City of Albuquerque Stormwater Construction Site Inspection Report

General Information						
ESC File No.	L15E051A	Project Name:	Raising Cane's			
NPDES Id. No.	NMR1005S1	Location:	1401 Gibson Blvd SE			
1/10/2024	Owner -		Contractor			
Operator	Raising Cane's Restaurants, LLC		Embree Construction Group Inc.			
Contact name & title	Robert Montgomery		Shane Craven			
e-mail	rmontgomery@raisingcanes.com		scraven@embreegroup.com			
Contact Phone #	972-769-3364		512-630-9651			
COA Inspector	Doug Hughes		Start/End Time:	3:30PM		
Construction Phase:	Framing & Utilities					
Type of Inspection:	Regular	Storm Event	Past Storm Event >0.25"	311/Complaint	Follow Up	
Weather at time of inspection?		Cloudy		Temperature: ~		45
Estimated date of last storm 0.25" or greater			1/4/2024

C3.1

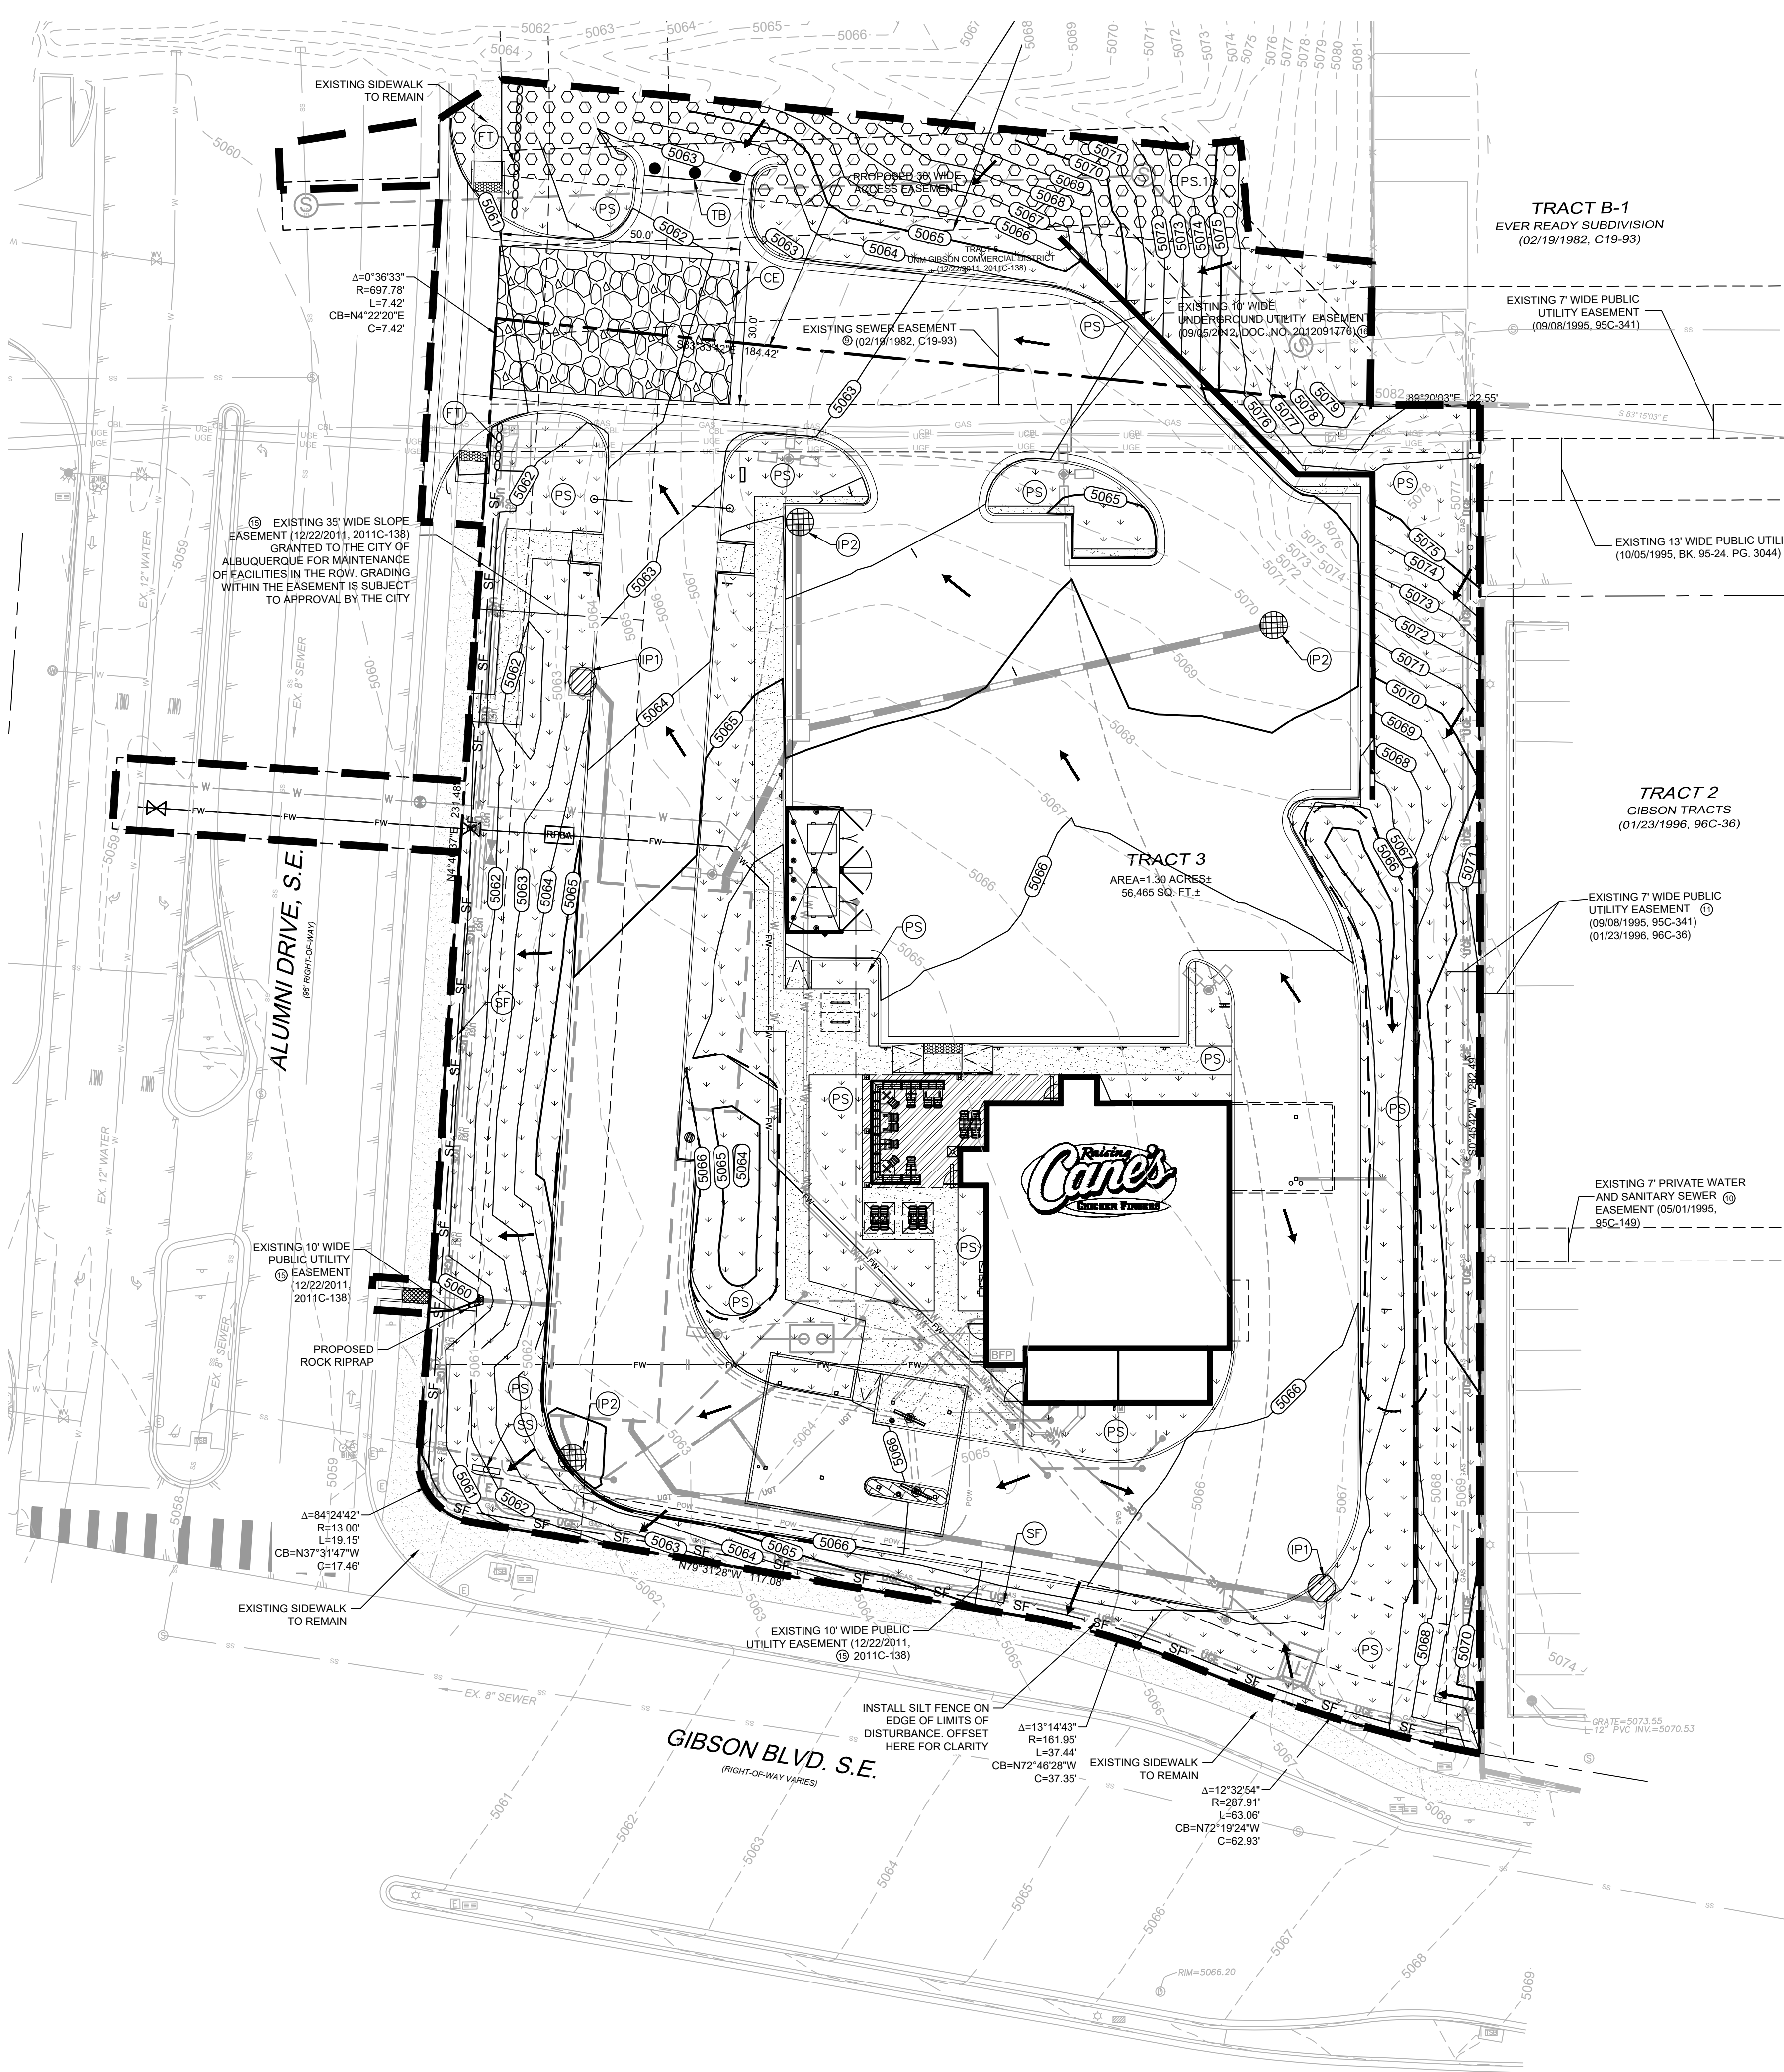
3	<p>BMPs - The stormwater controls were missing at the construction support activities on Tract 5 north of the raising Cane's site in violation of CGP 2.1. Perimeter controls were missing in violation of CGP 2.2.3 at the Construction Support Activity on Tract 5 and on the west side of the site. The track-out control was covered by dirt in places and needs to be reset. Required Mitigation: You must ensure that stormwater controls (BMPs) for Tract 5 are designed, installed, and maintained as required in Parts 2.2, 2.3, and 2.4 to minimize the discharge of pollutants in stormwater from construction activities as required by CGP 2.1. You must Install sediment controls along any perimeter areas of the site that are downslope from any exposed soil or other disturbed areas, as required by CGP 2.2.3. You must minimize sediment track-out by preventing access to the unpaved portion of the Alumni Dr. right-of-way. When the problem requires a new or replacement control or significant repair, install the new or modified control and make it operational or complete it by no later than seven (7) calendar days from discovery per CGP 5.2.1.</p>
